**RE: AC Hotel Portland
Response to Staff Review Comments**

On behalf of Portland Norwich Group, LLC we are pleased to submit this response letter to the Level III - Final Site Plan Review Comments from the City Staff along with supporting materials relating to the proposed hotel. Below are the comments taken from the Staff Review Letter (*in italics*) along with responses from the applicant (**in bold**) as well as a summary on one additional site plan modification proposed by the applicant.

6 GRANITE TREE PLANTER AND PLANTING DETAIL

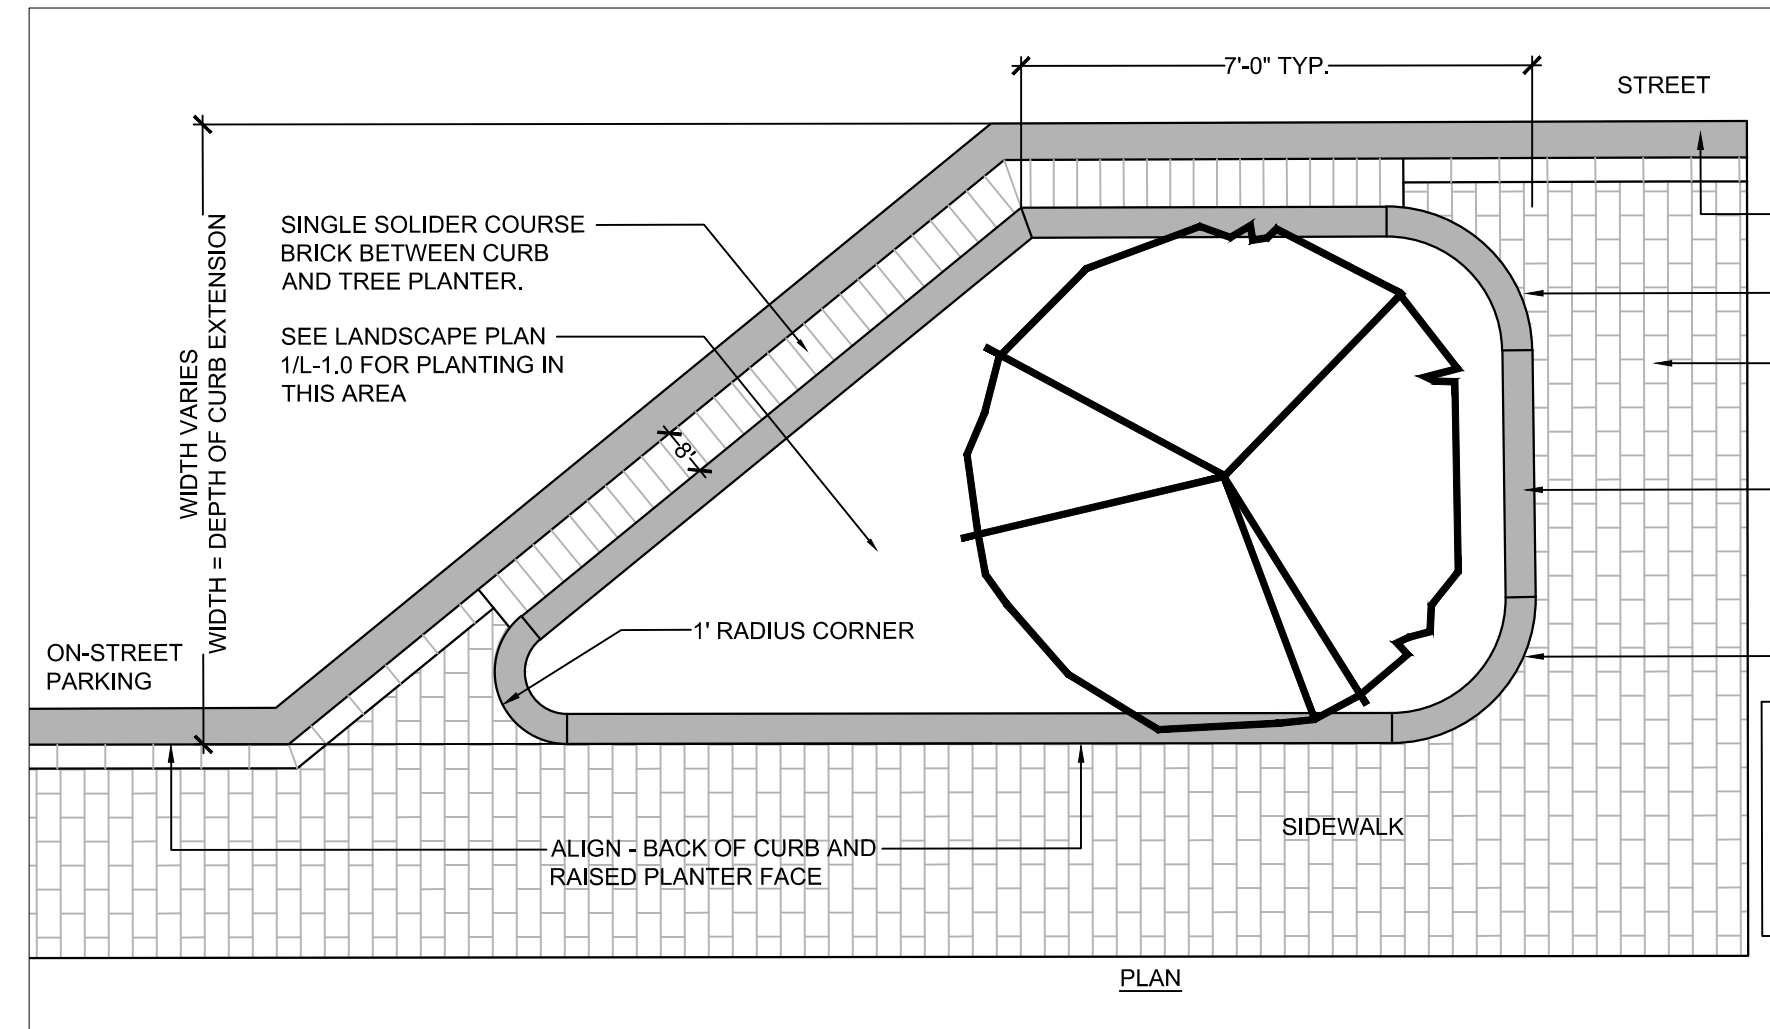
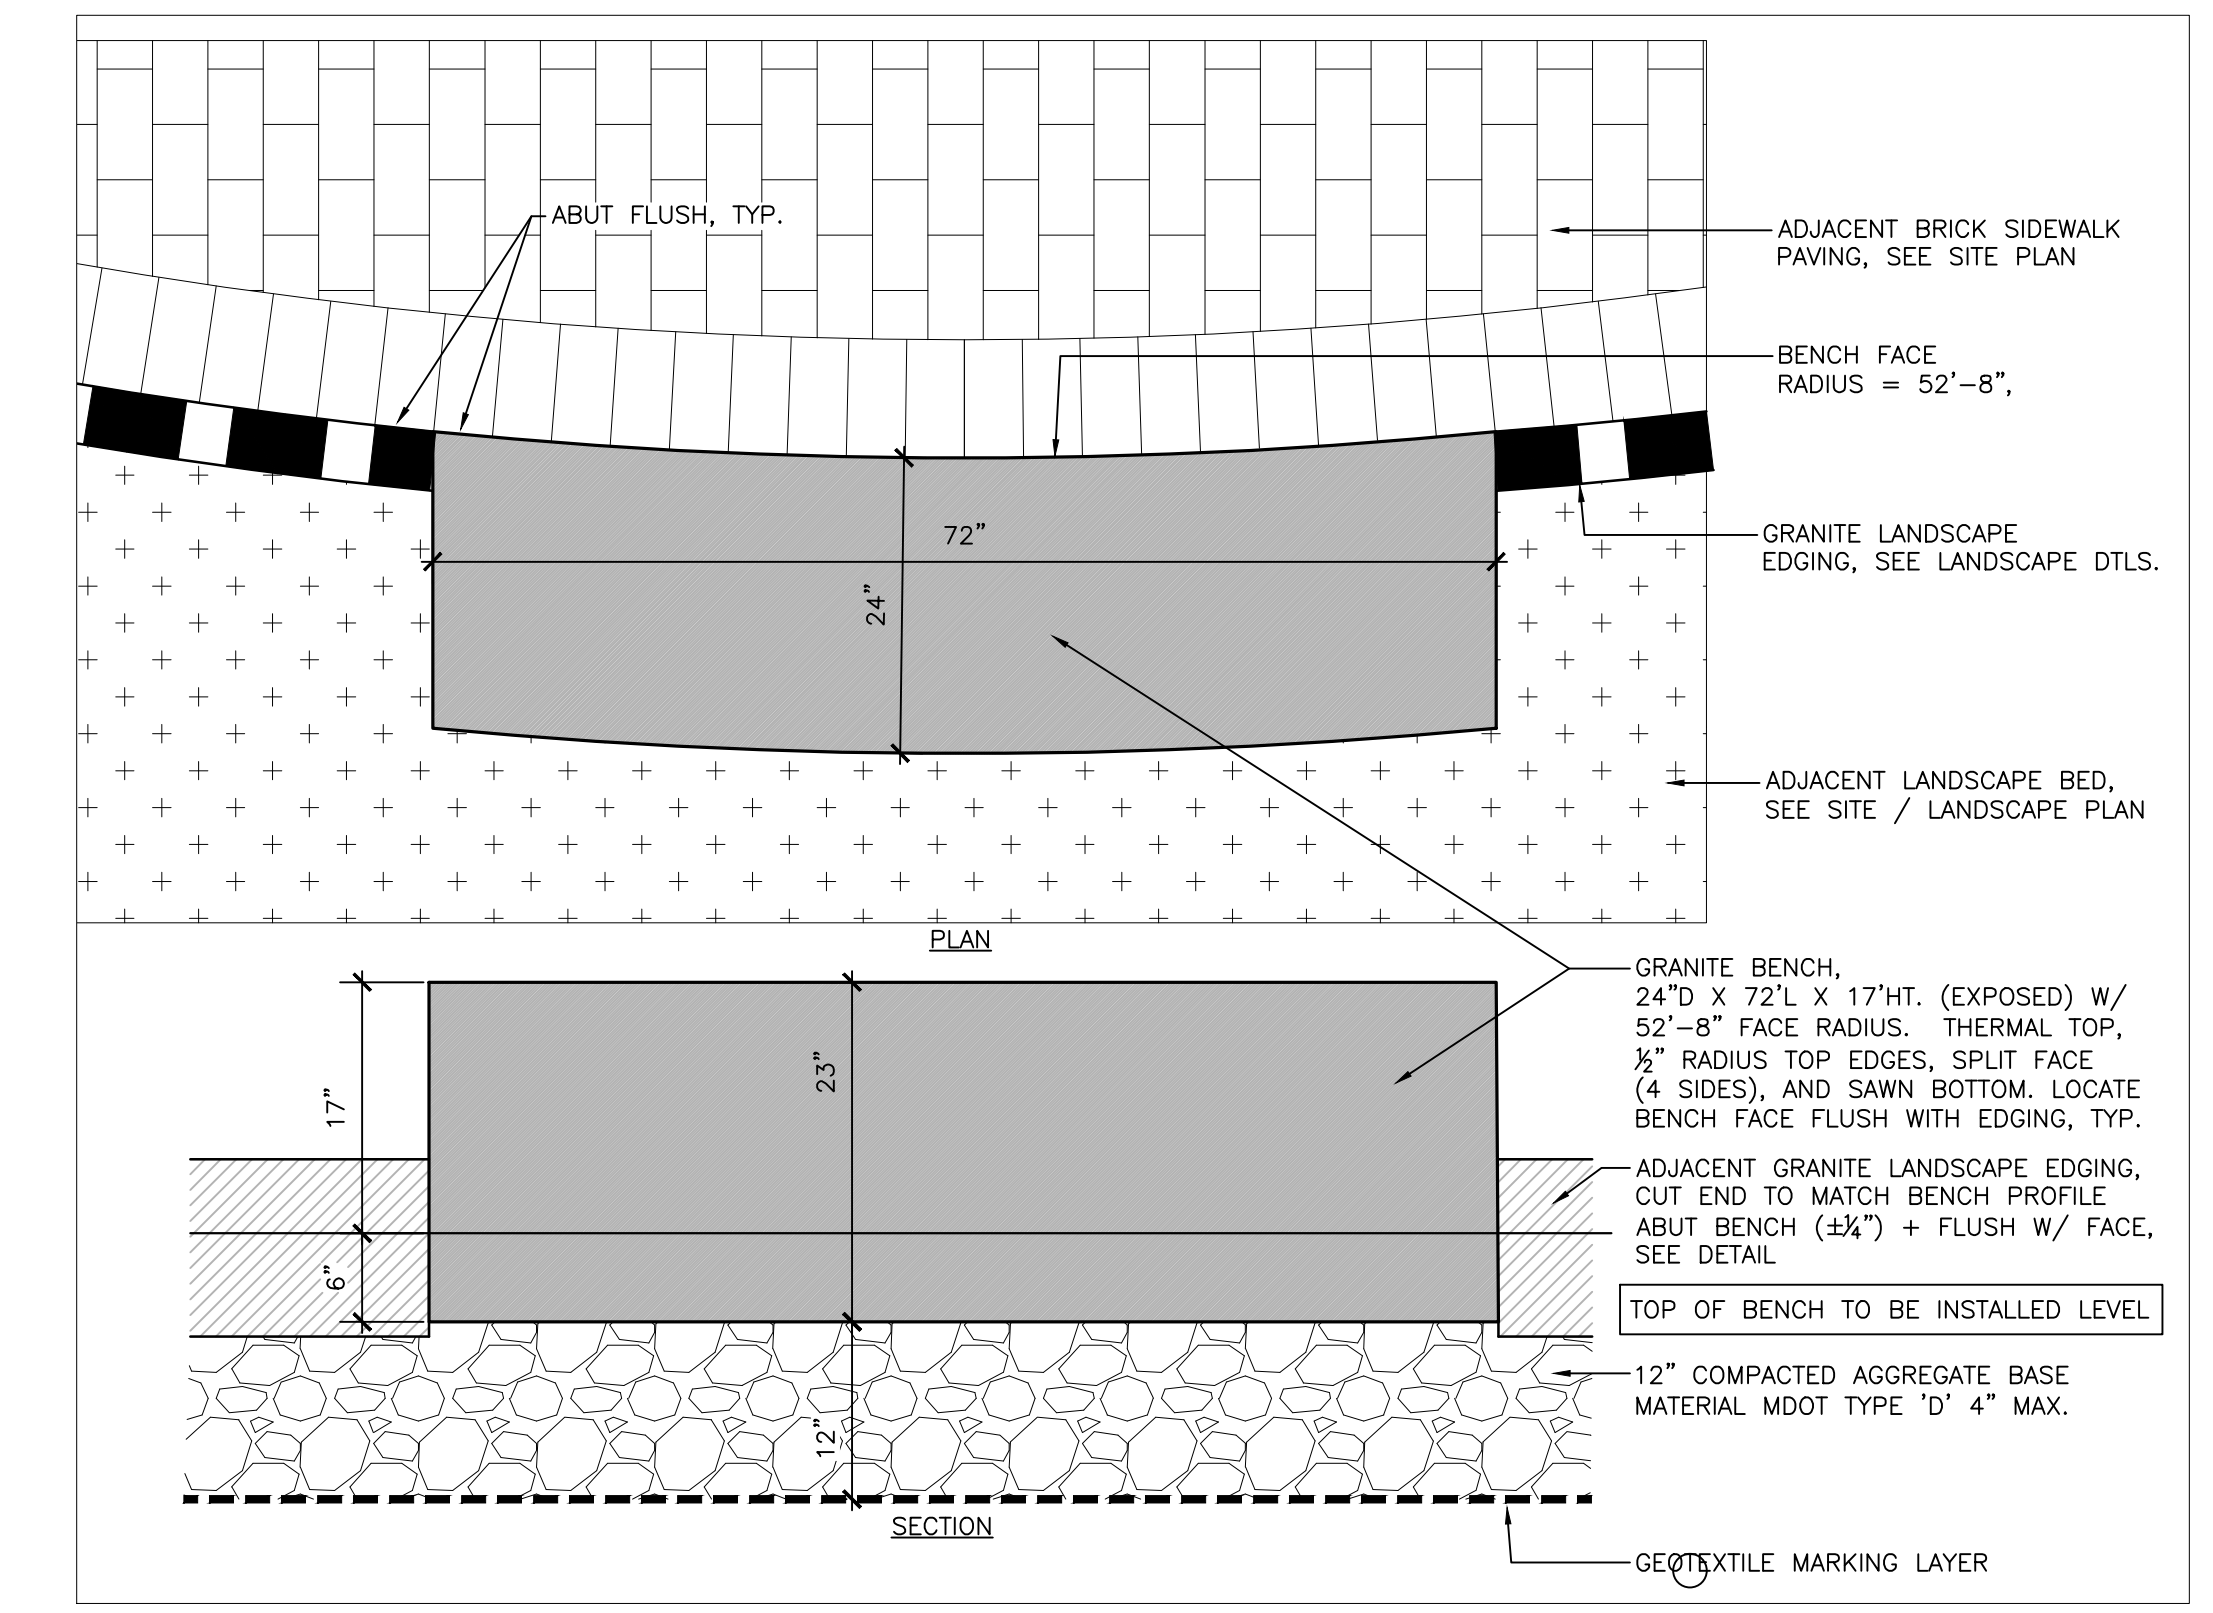
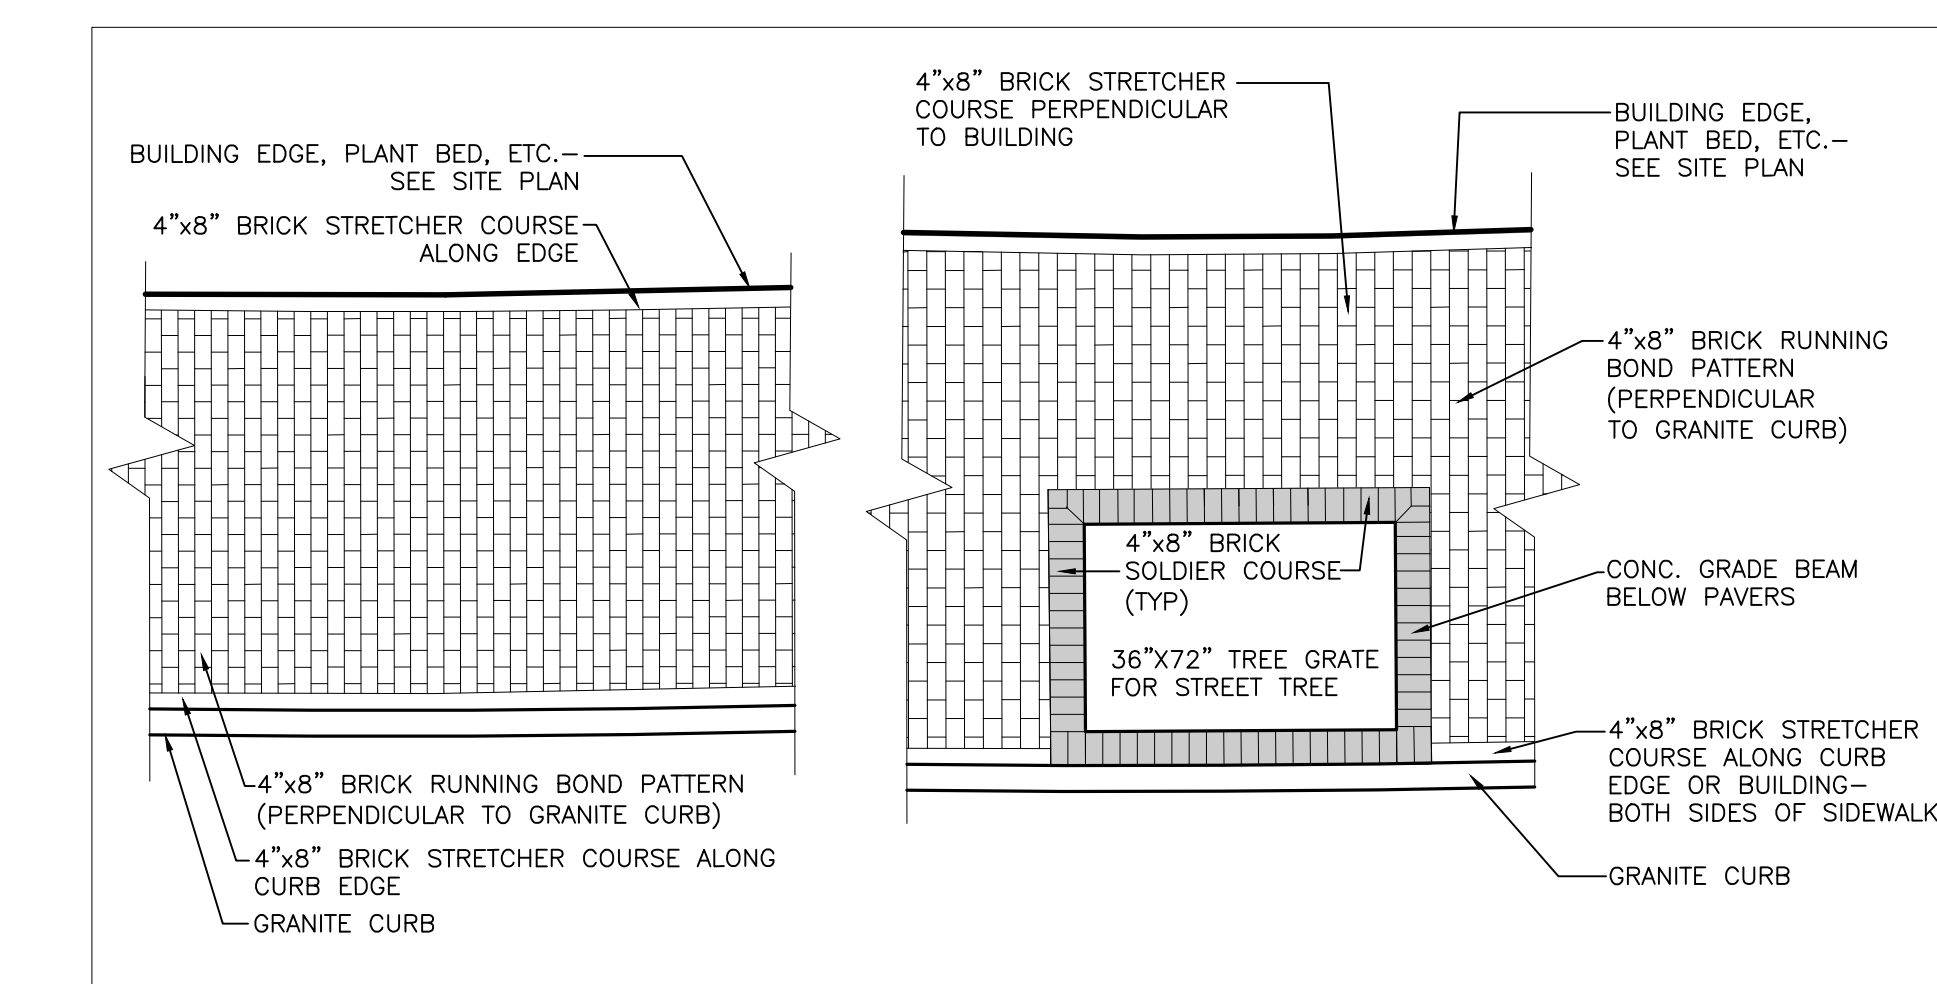
We met with the City Arborist on April 13 to go over his review comments. He suggest that the proposed raised granite tree planters at the end of the on-street parking, within the curb extensions, be located at the end of the parking to help delineate it and to prevent odd left over spaces in the sidewalk. He also recommended that these specific tree planters should be more triangular in shape to fit the space better and larger to allow for additional low planting to happen.

RESPONSE: We have incorporated four alternative style raised tree planters (with under planting of perennials) into the streetscape; two each at the curb extensions at Fore/Hancock and Thames/Hancock.

3 PRECAST CONCRETE CATCH BASIN-TYPE 'F'
NOT TO SCALE

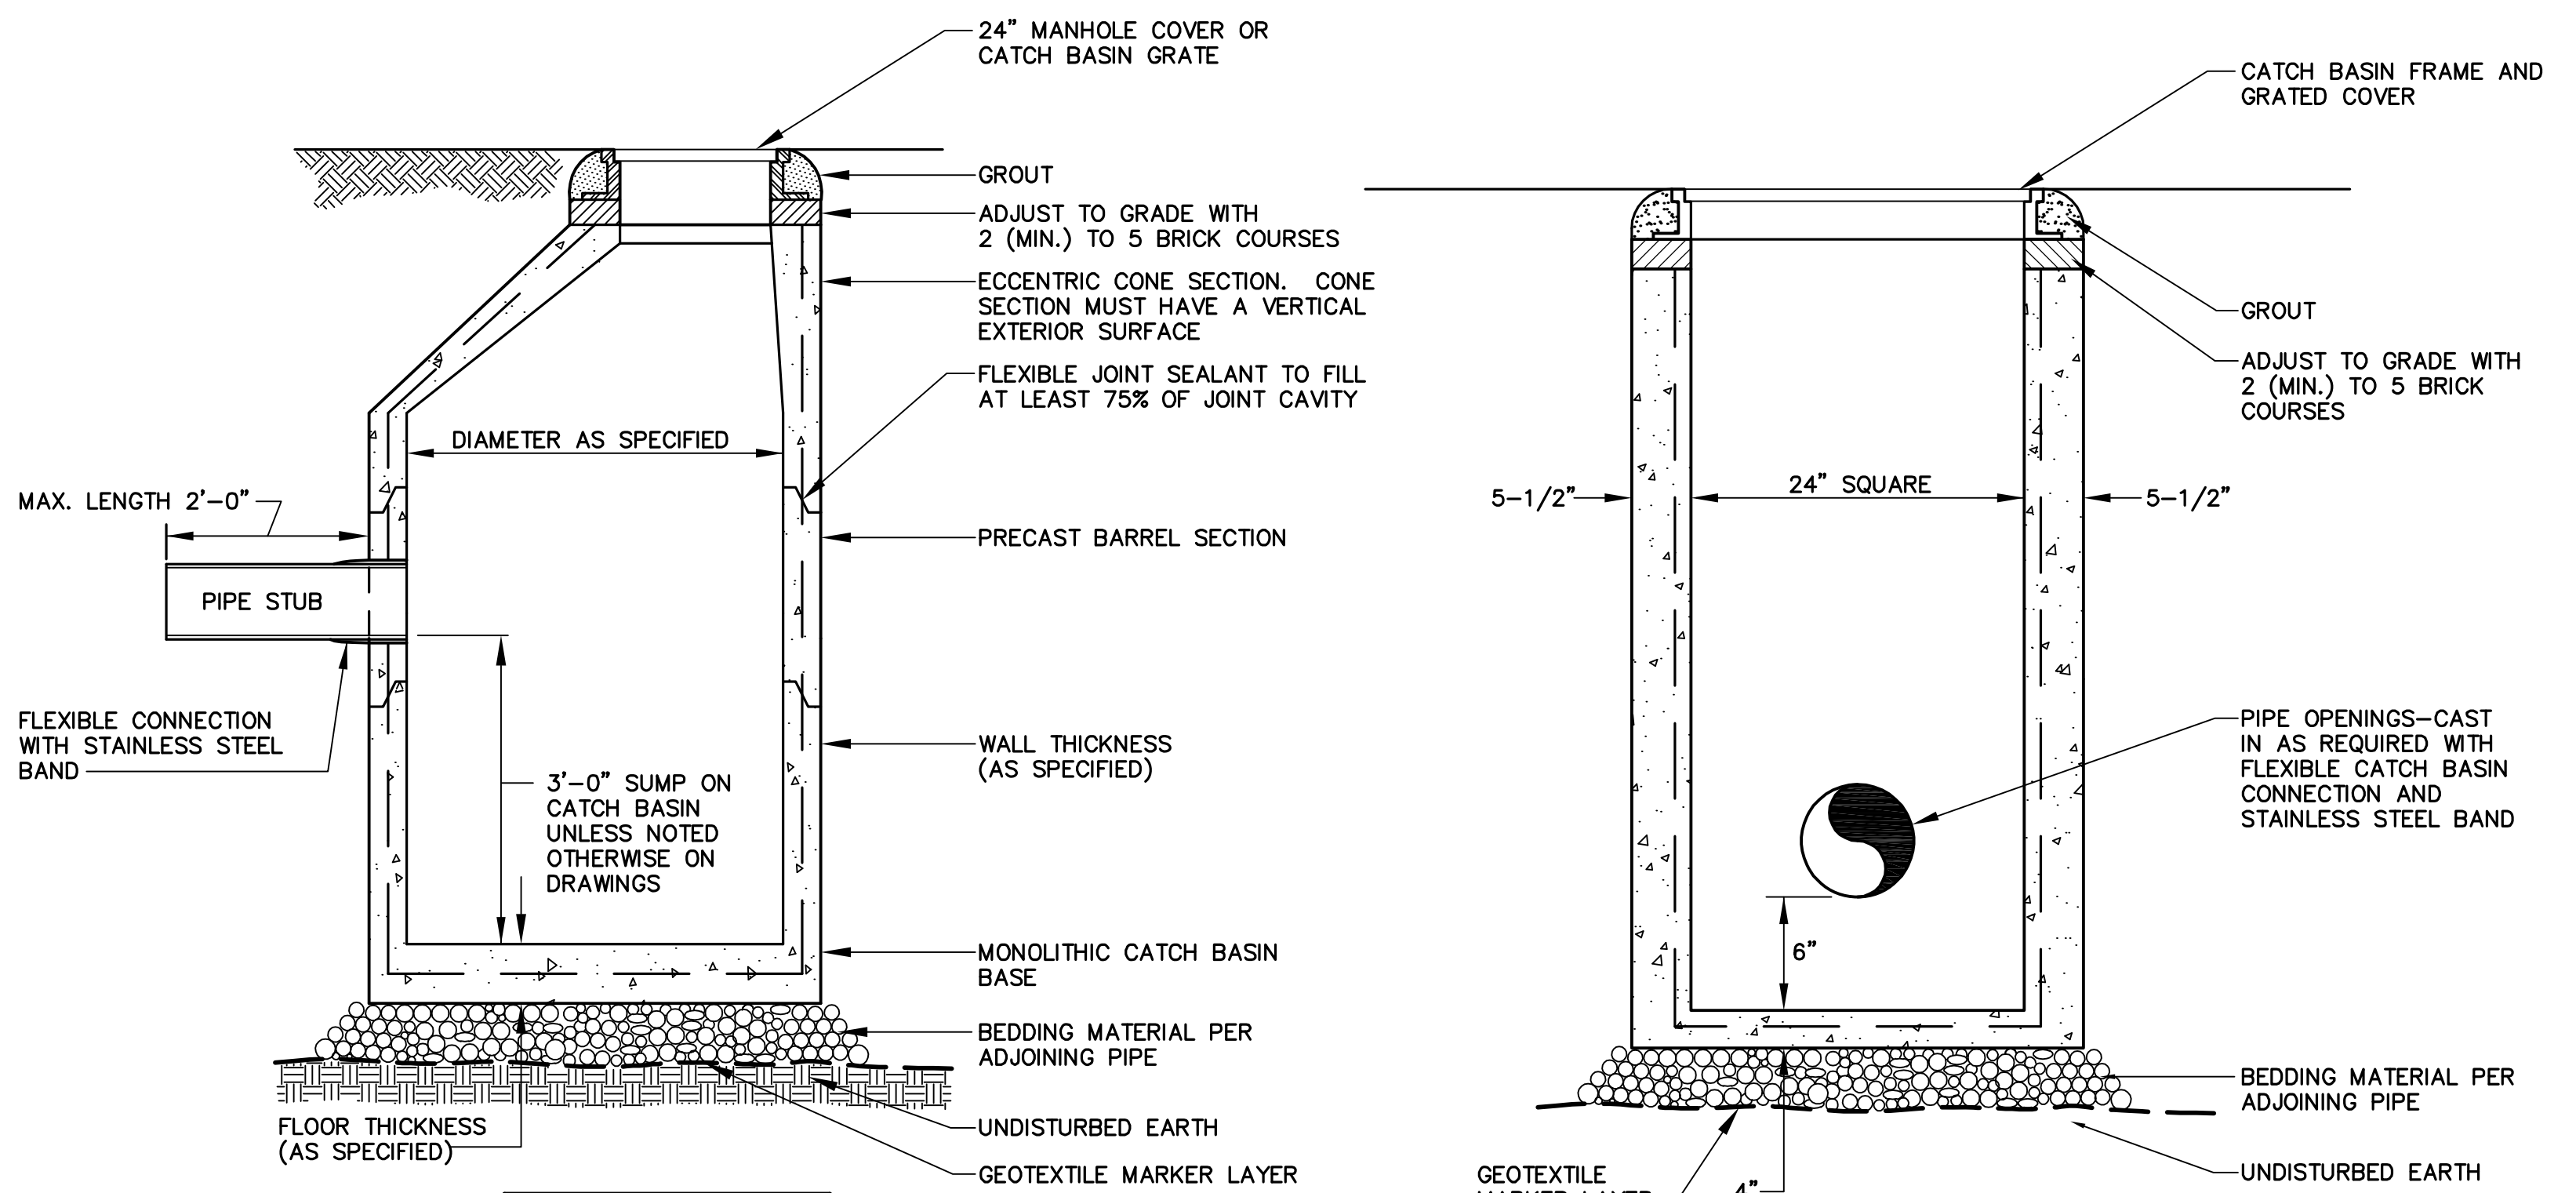
13. The City's Technical Manual require of catch basin which discharge to the City's stormwater system to have three foot sumps. Please change plan details to reflect this requirement.

RESPONSE: The type F basins shown on the plans discharge to the R-Tank storage system and not directly to the City's stormwater system. However, the sump called out on detail 2, Sheet C2.2 has been revised.
